Project: PROP - Parkside Neighborhood Center
& Affordable Housing
77 - 85 Grant Street

Addendum #5

**The Parkside Neighborhood Center
and Affordable Housing
Mellen & Grant Streets,
Portland, Maine 04101**

May 3,2004

HVAC2.3

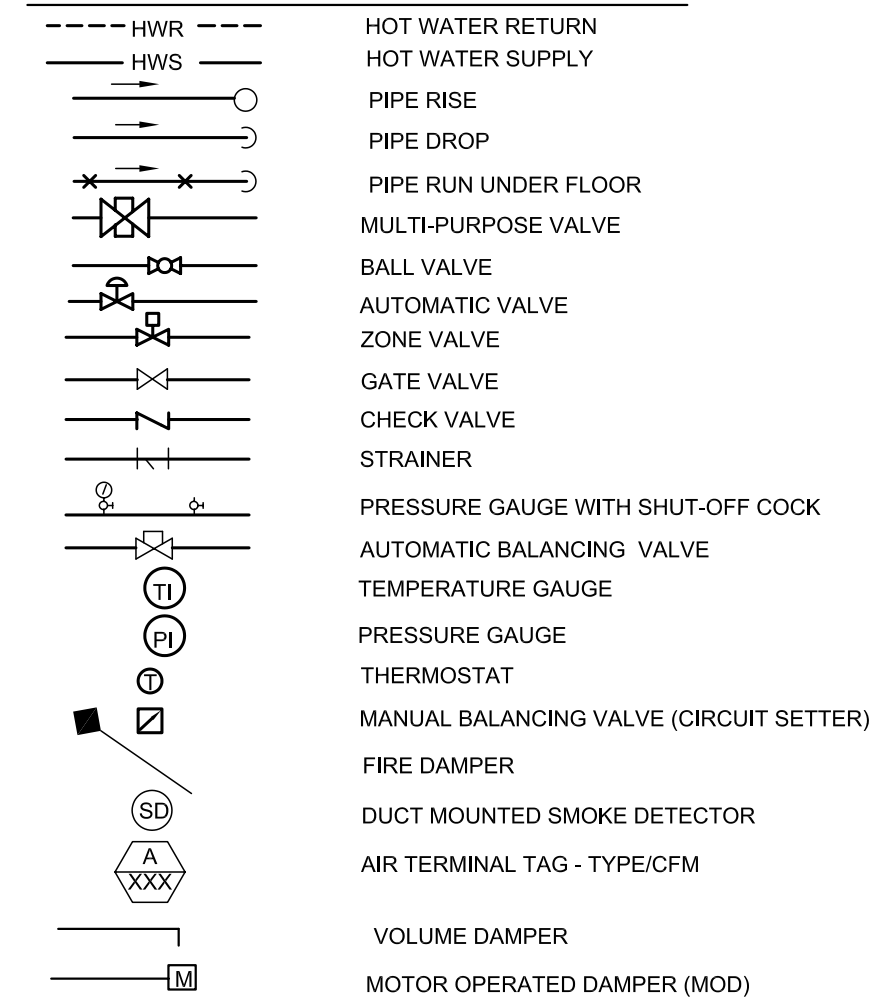
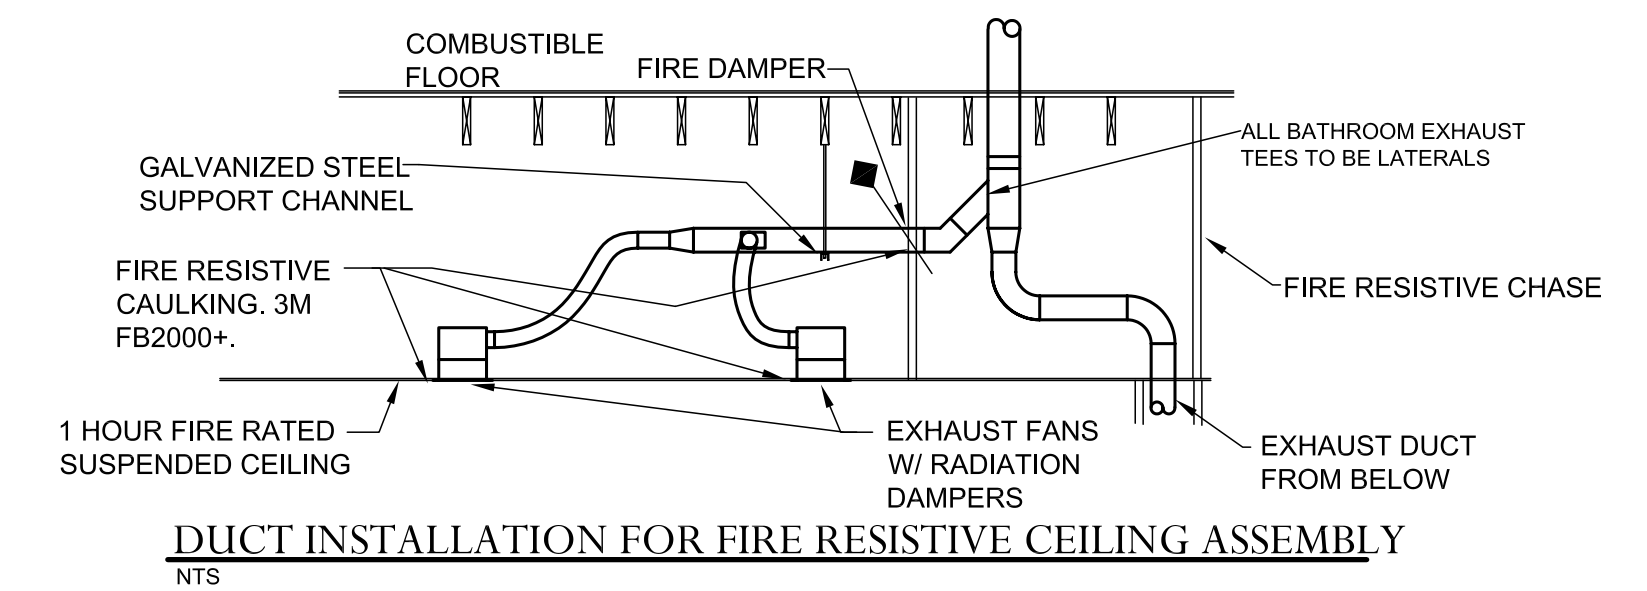
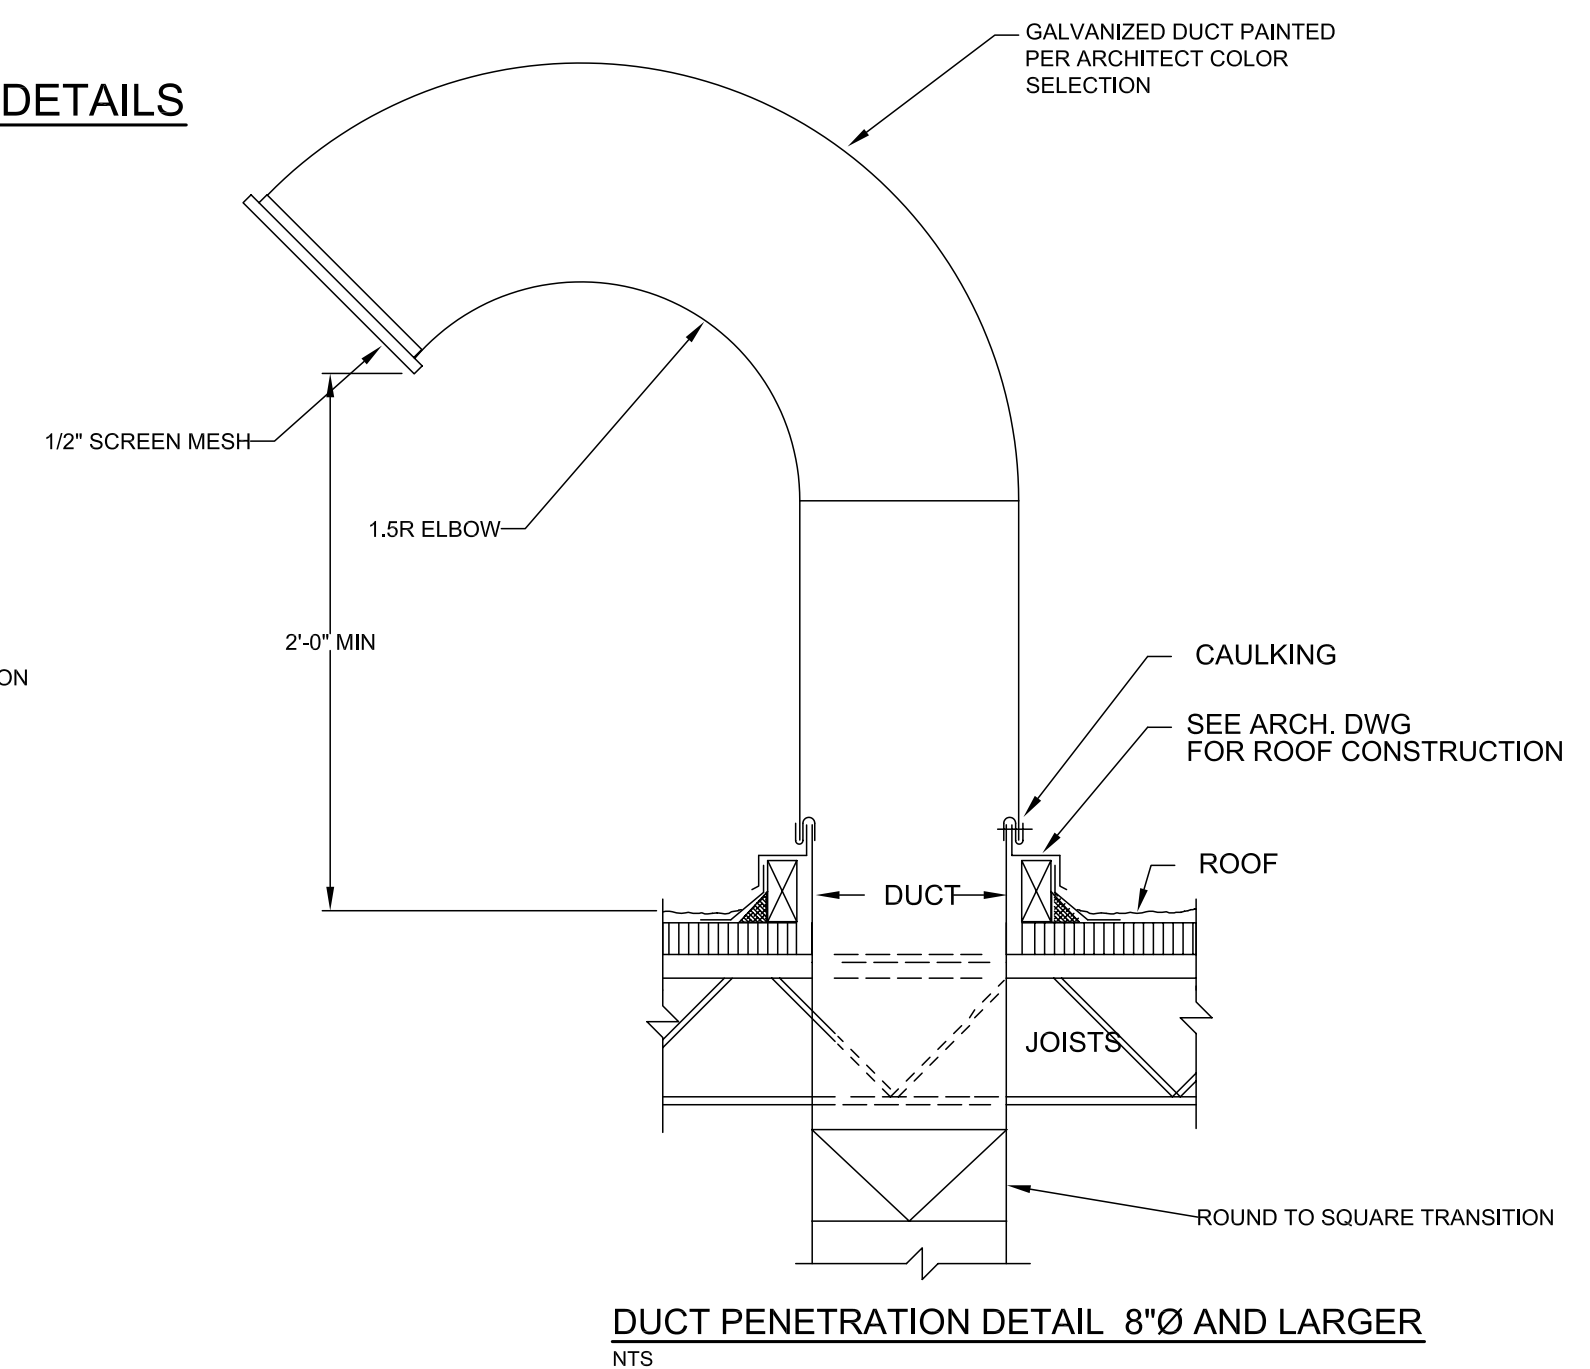
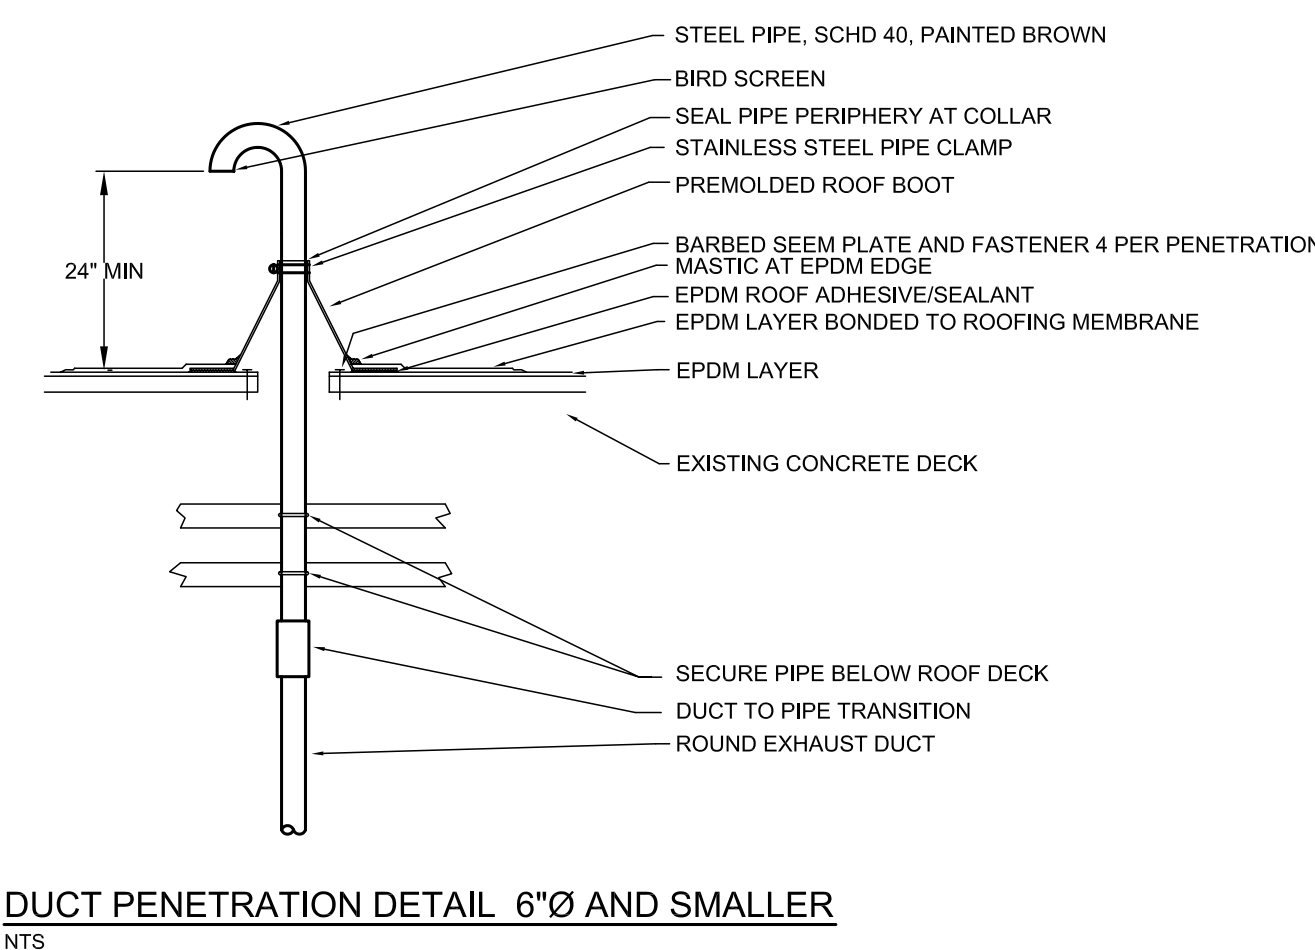
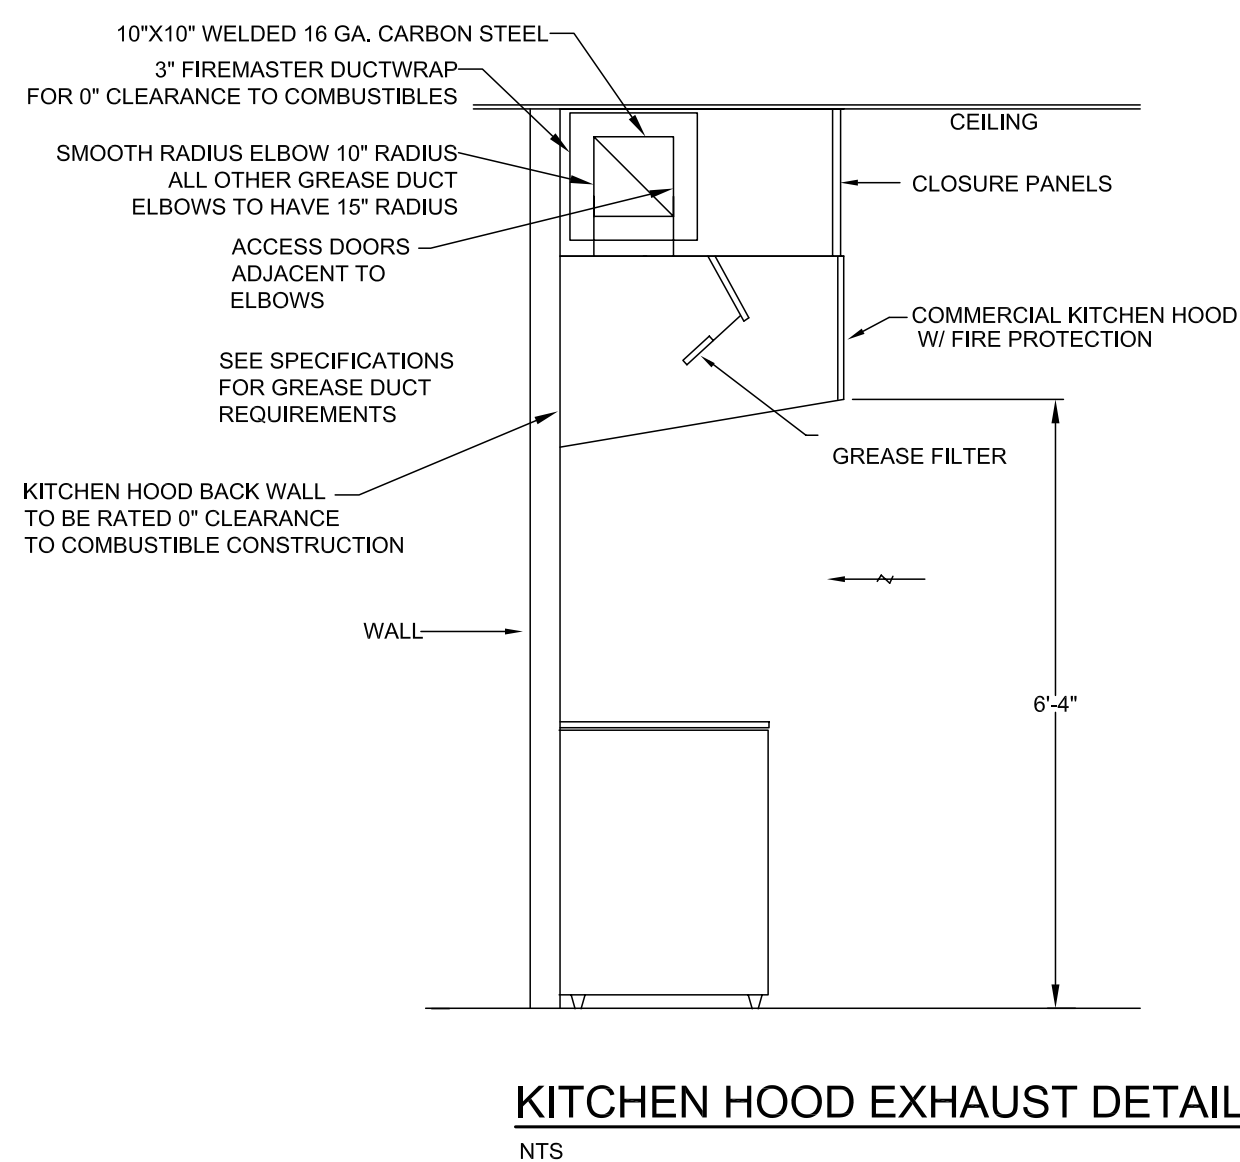
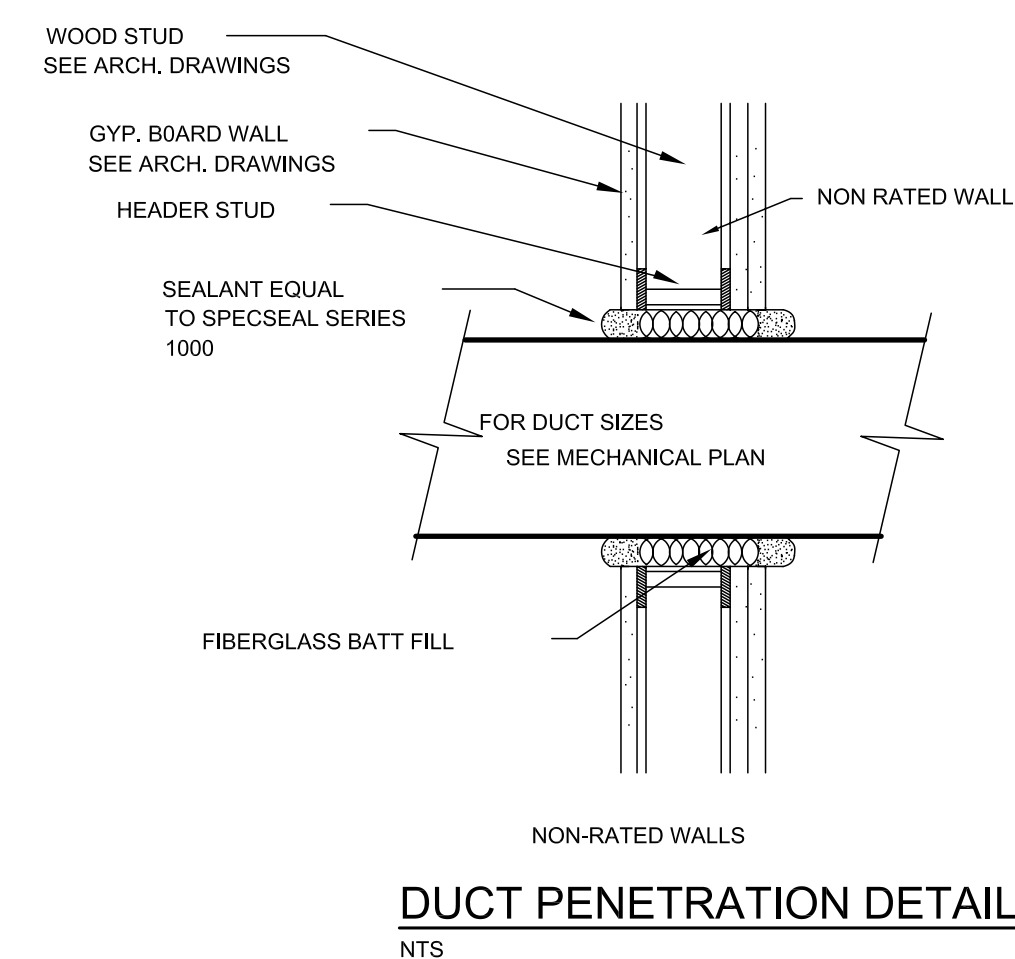
4-55	A/B HVAC2.3		ADD to the Mechanical General Notes the following:
------	-------------	--	--

1. Add Mechanical General Note 10:
Provide additional fire damper and access door:
 - a. At ducts penetrating walls of shafts both at entrance in Basement and exit in Attic, including residential kitchen hood ducts. Note: Do not install fire damper in commercial hood exhaust duct in Building A.
 - b. At ducts penetrating 3rd floor ceiling-attic "floor". Examples are duct risers into attic from 3rd floor bathroom exhaust fans tagged EF-1. Penetrations are shown on Drawing HVAC 1.4 also.
2. Add Mechanical General Note 11:

Provide 4" Schedule 40 PVC radon exhaust from slab penetration **up** boiler vent shaft, through attic space and roof. Terminate with 90 degree gooseneck similar to "Duct Penetration Detail 6" diameter and Smaller" shown on Drawing HVAC 2.3 (Note: delete words, "existing concrete deck"). Support PVC pipe in shaft. Allow space for future radon exhaust fan in vertical rise between attic "floor" and roof deck.
